Ms Nellie O'Keeffe
Project Director
Deutsche Bank Place
Level 19, Suite 19.02, 126 Phillip Street
Sydney NSW 2000

**Pitt Street South OSD Request for Additional Information
Stage 1 Modification (SSD 8876 MOD 1) & Stage 2 (SSD 10376)**

PROJECTIONS BEYOND THE BUILDING ENVELOPE

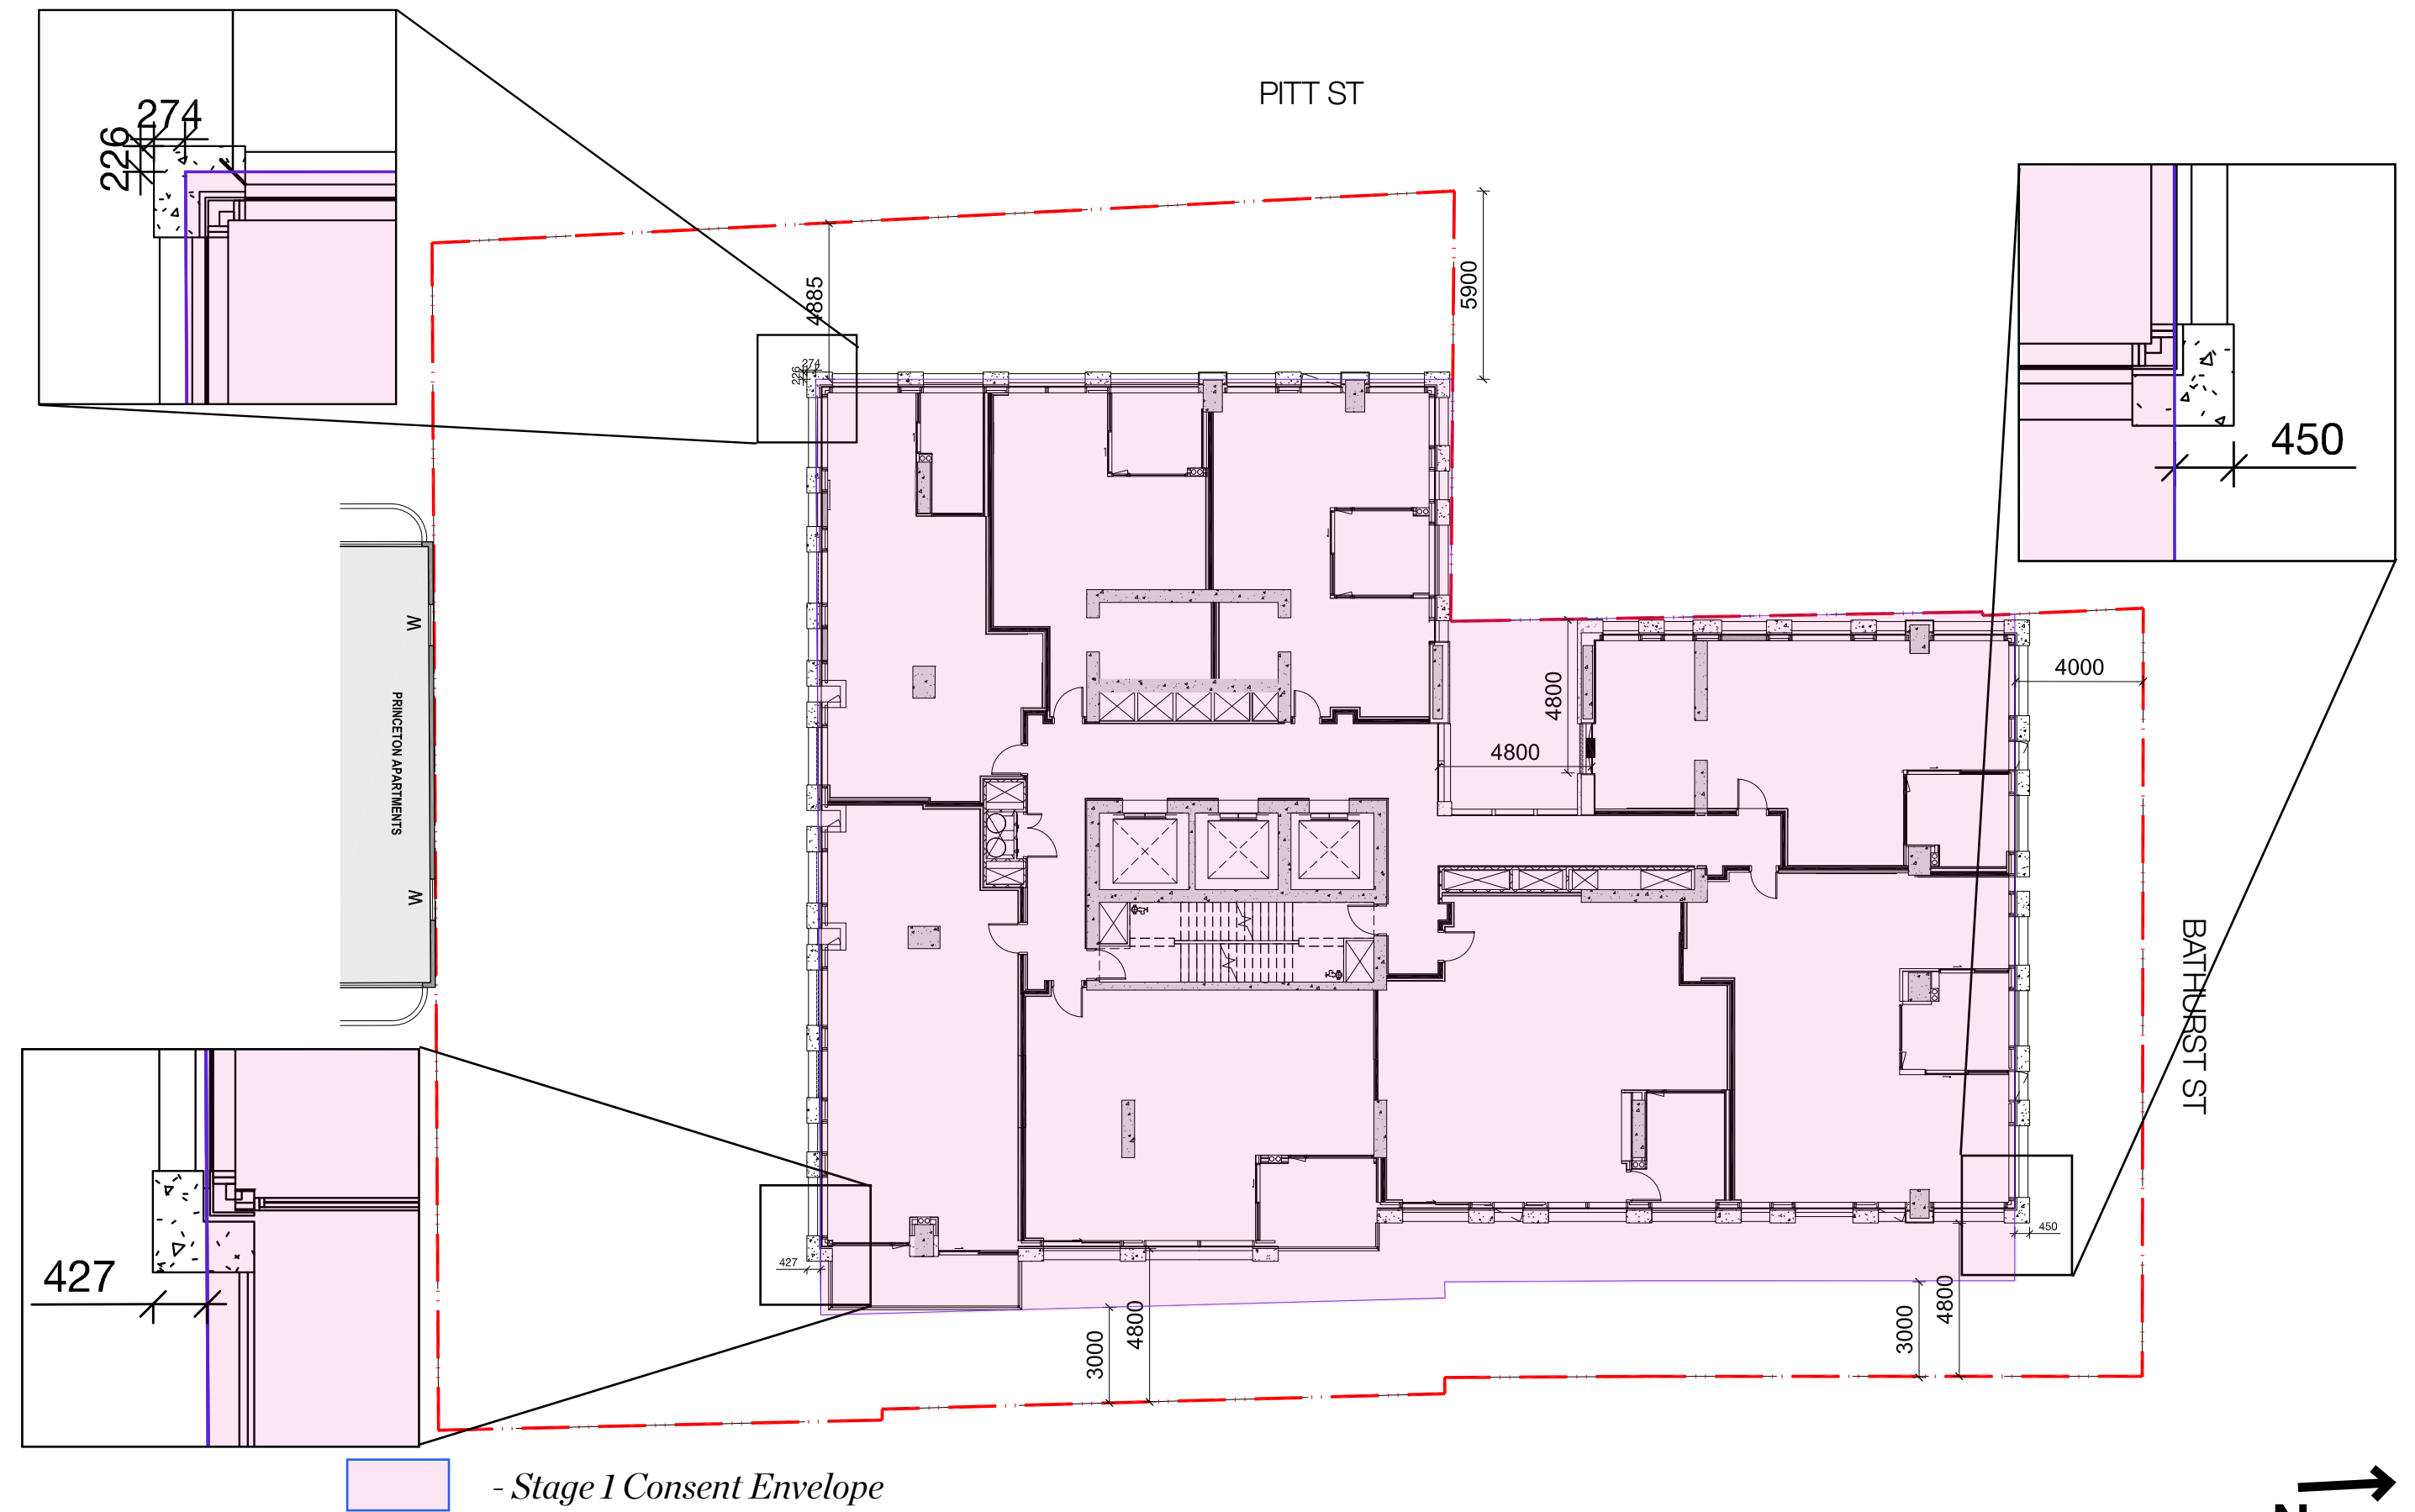
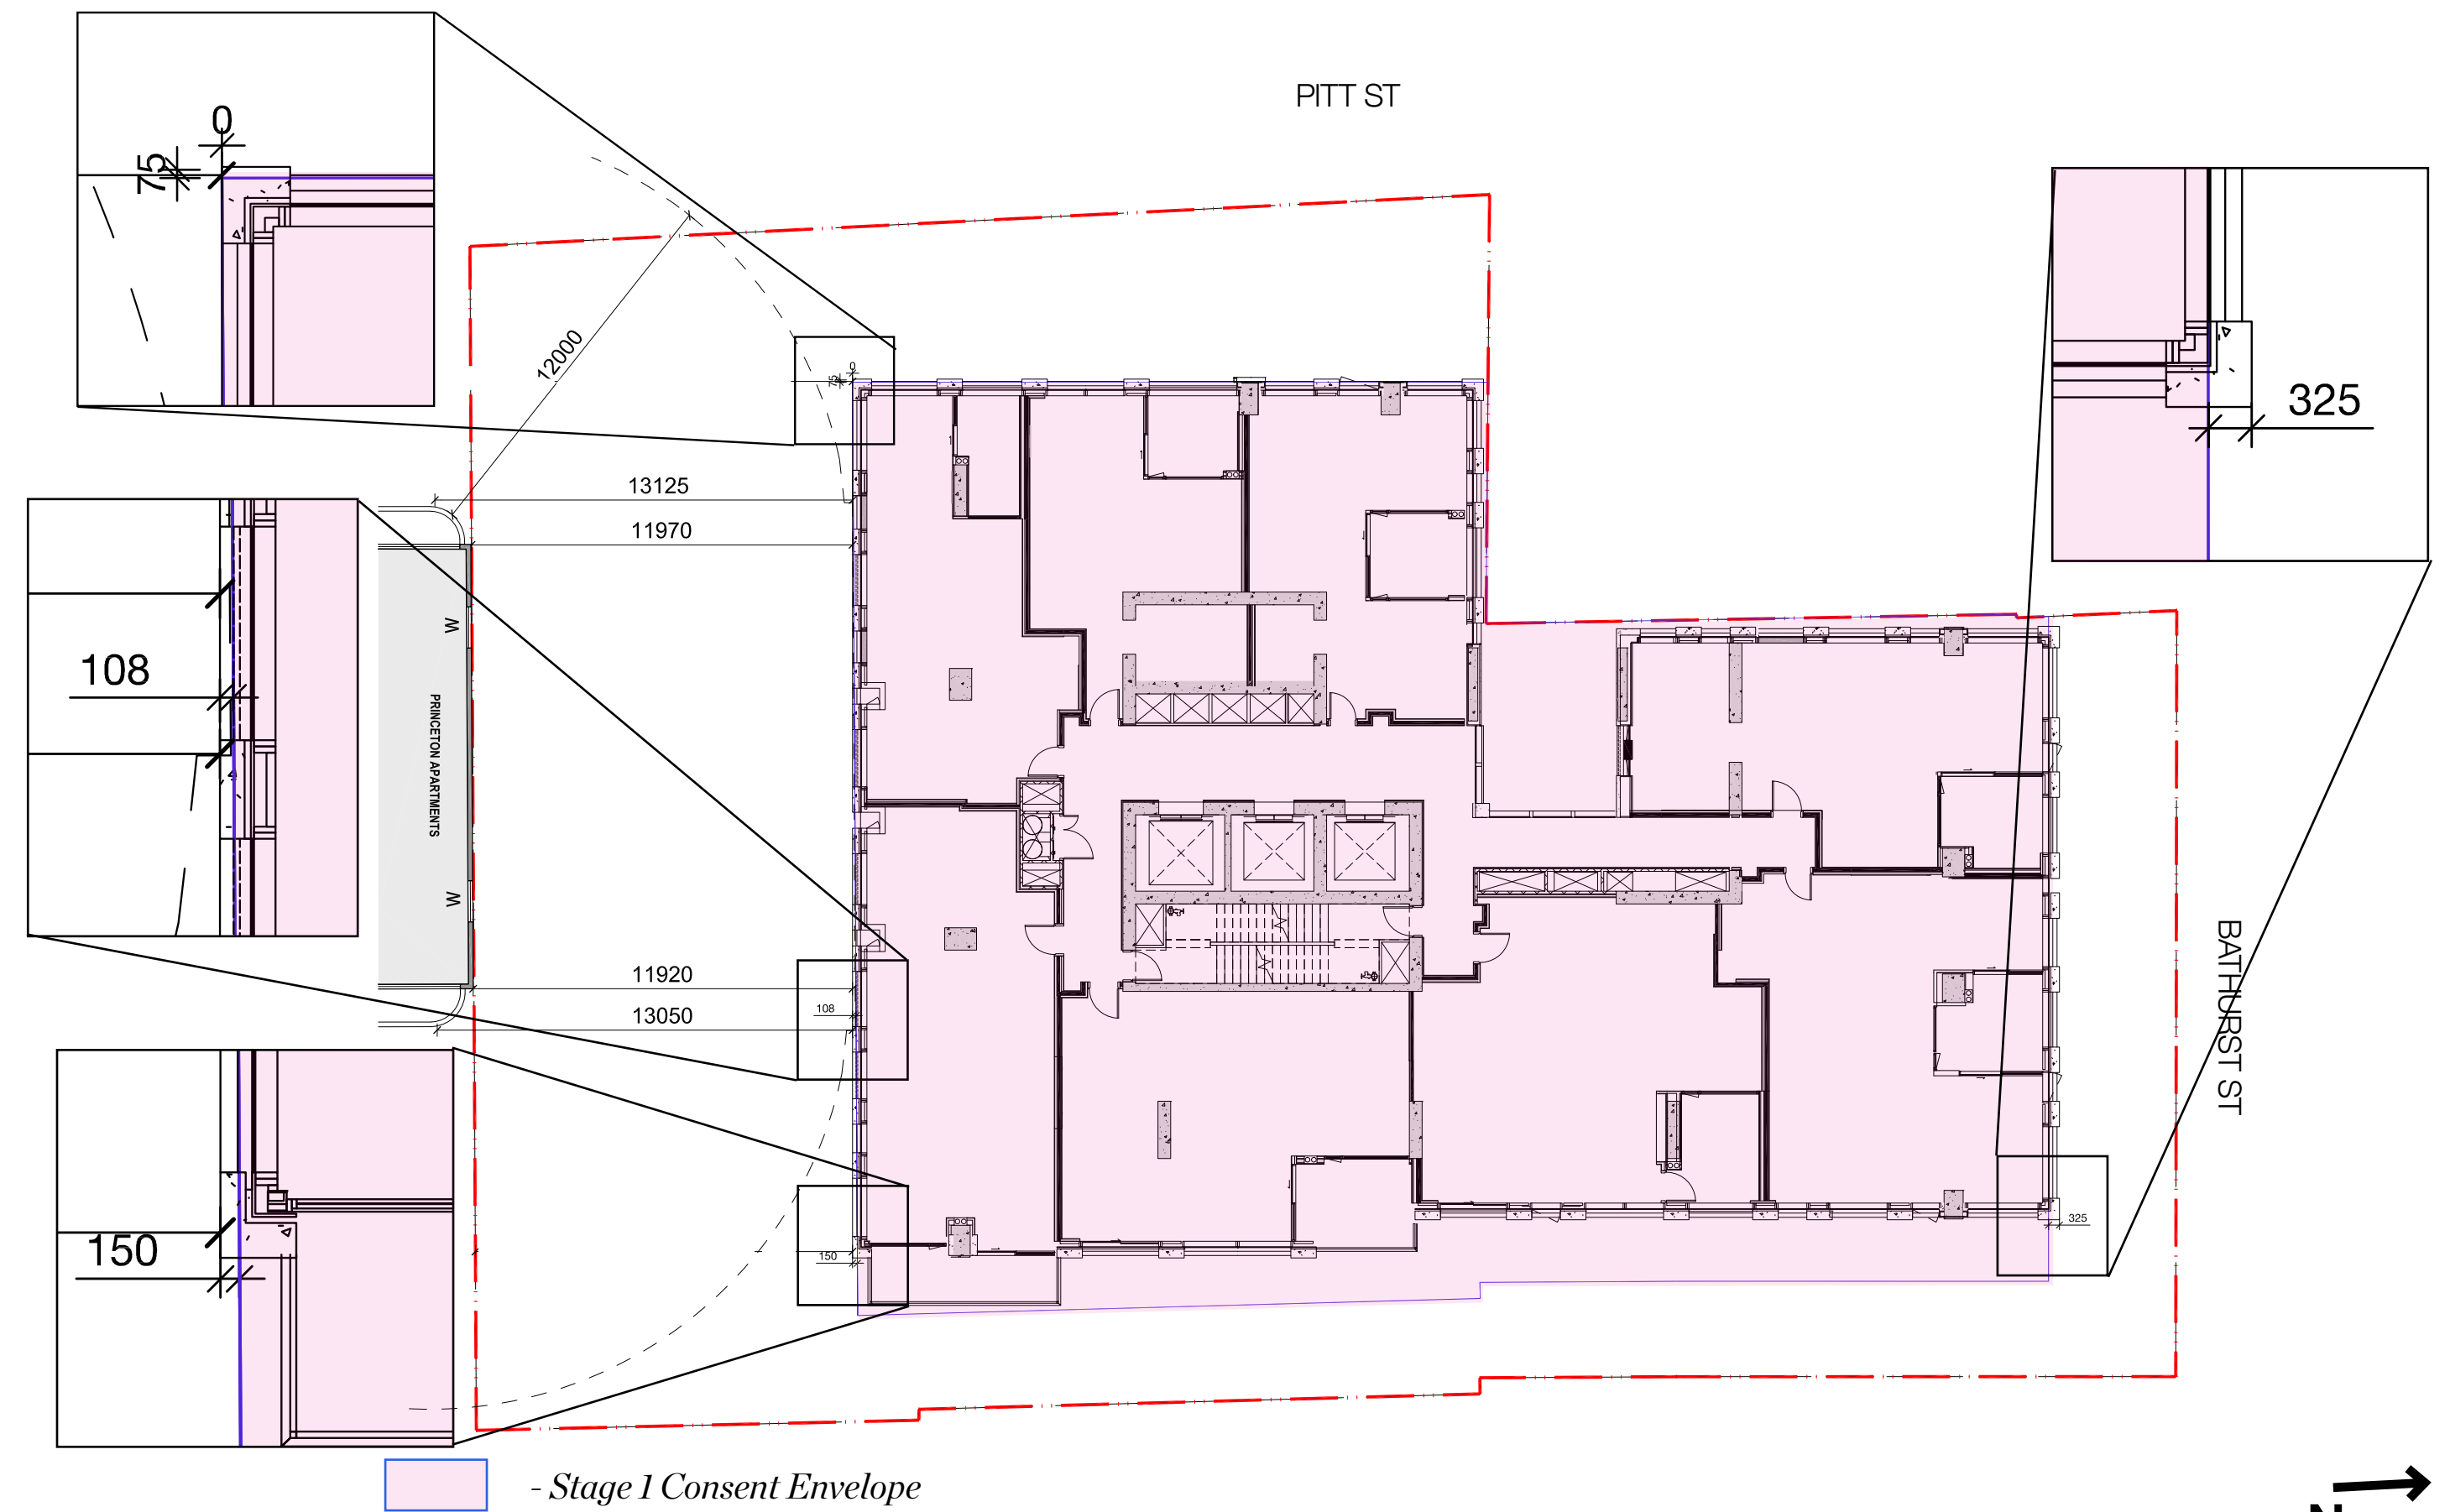
- Describe and illustrate the amendments to the proposed GRC columns/façade configuration between the RTS and current scheme, including updated architectural drawings and visualisations.
- Confirm whether the changes to the GRC columns will affected various analysis submitted with the RtS and submit updated documents where necessary, particularly:
 - the supplementary solar analysis statement provided by Walsh Analysis, dated 10 November 2020
 - projections/encroachment on the approved building envelopes and respective site boundaries
 - floorplate and/or GFA calculations.
- Provide an updated BASIX Certificate and stamped plans.
